Addendum No. 2

RE: Contract # C204350

Nash County (B-5980, BR-0036, BR-0039)

I-95 AT SR-1544 (HALIFAX RD), BRIDGE #41 OVER I-95 ON NC-33,
AND BRIDGE #224 OVER I-95 ON SR-1510

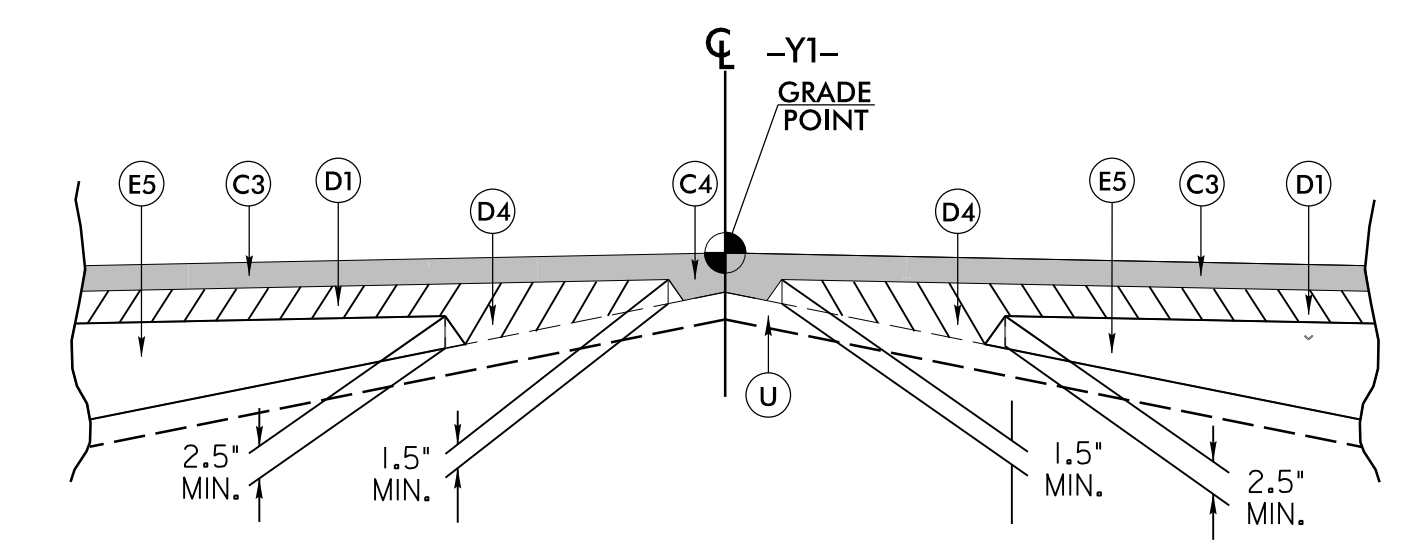
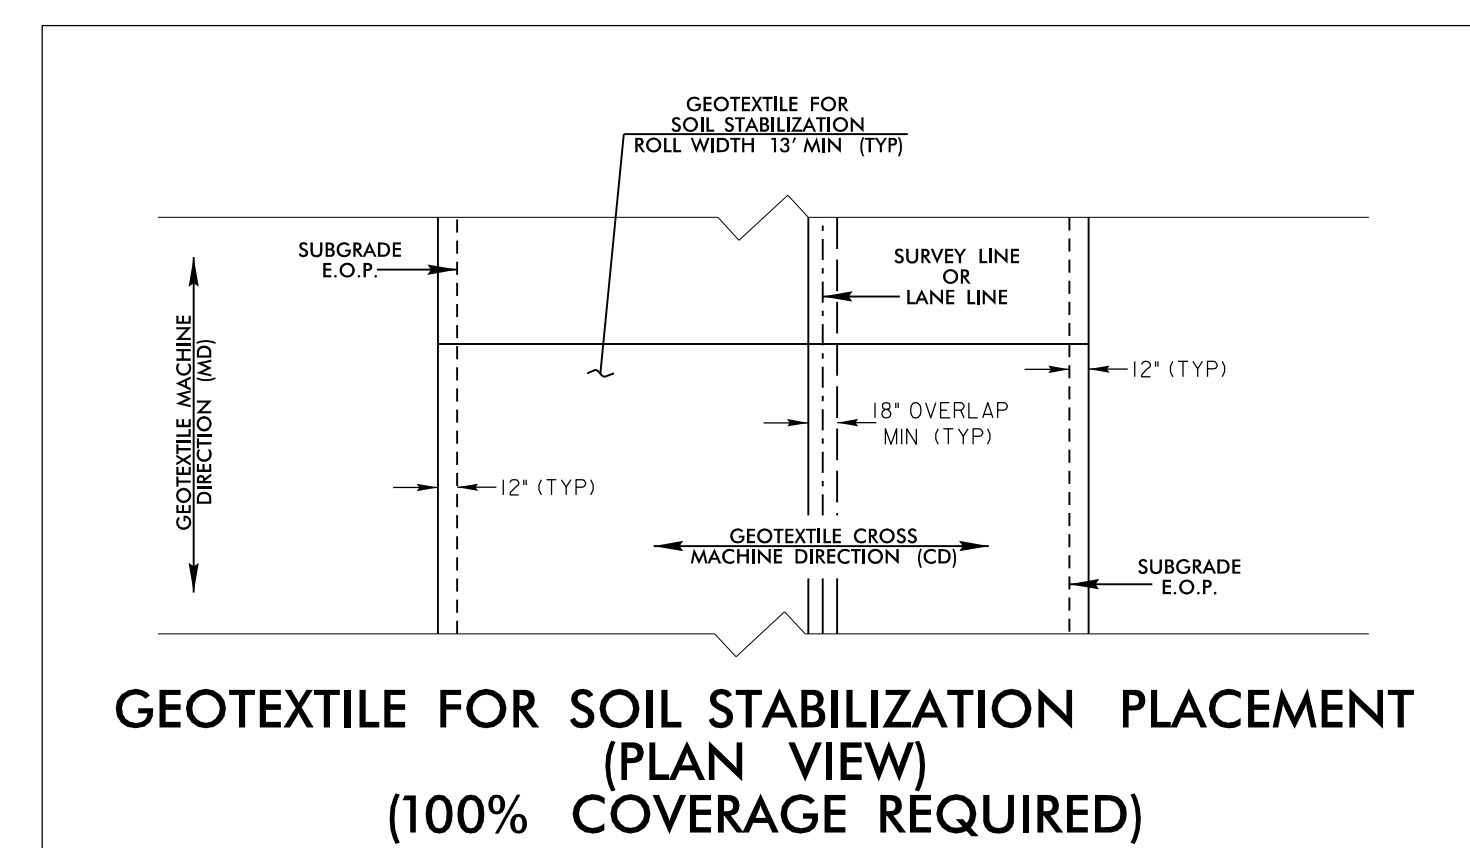
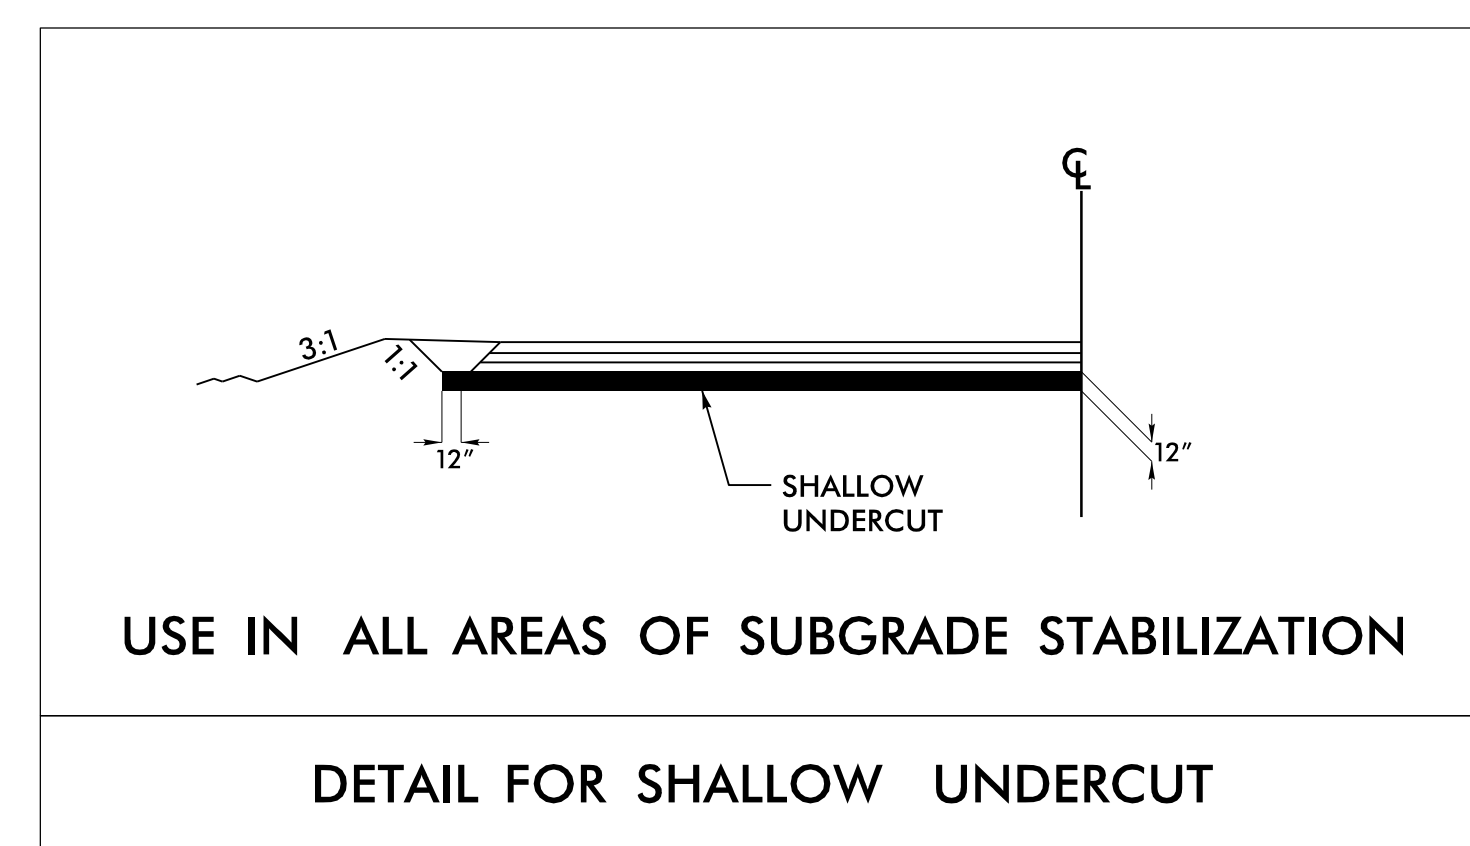
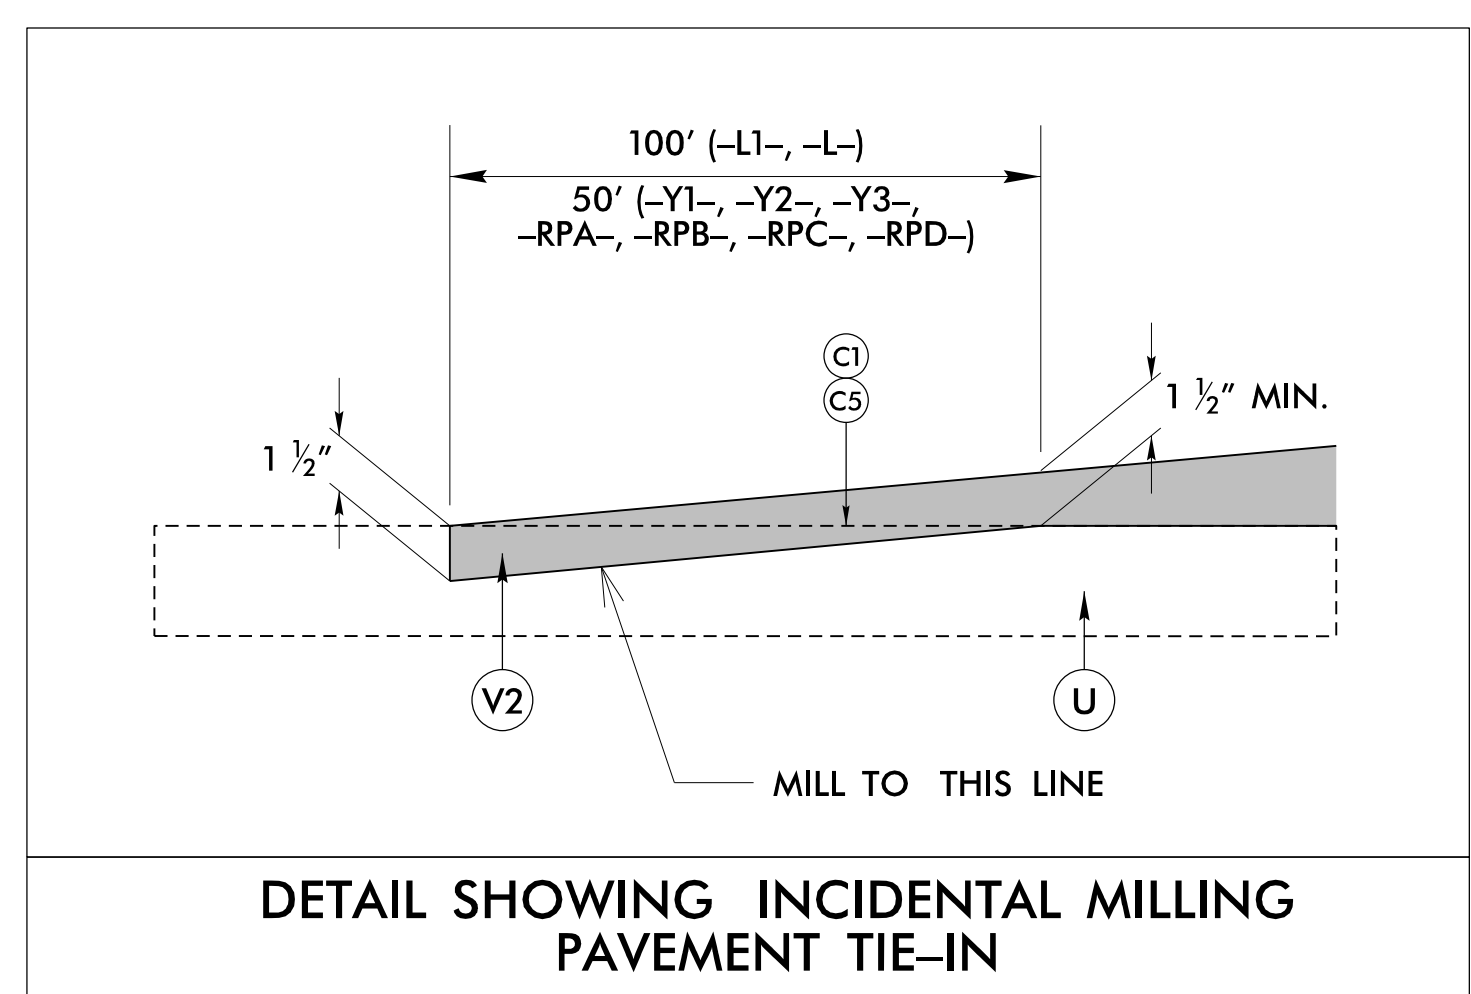
Sheet No.	Revision
2A-1	Pavement Schedule revised
2A-2	Typical Section and Pavement Schedule revised
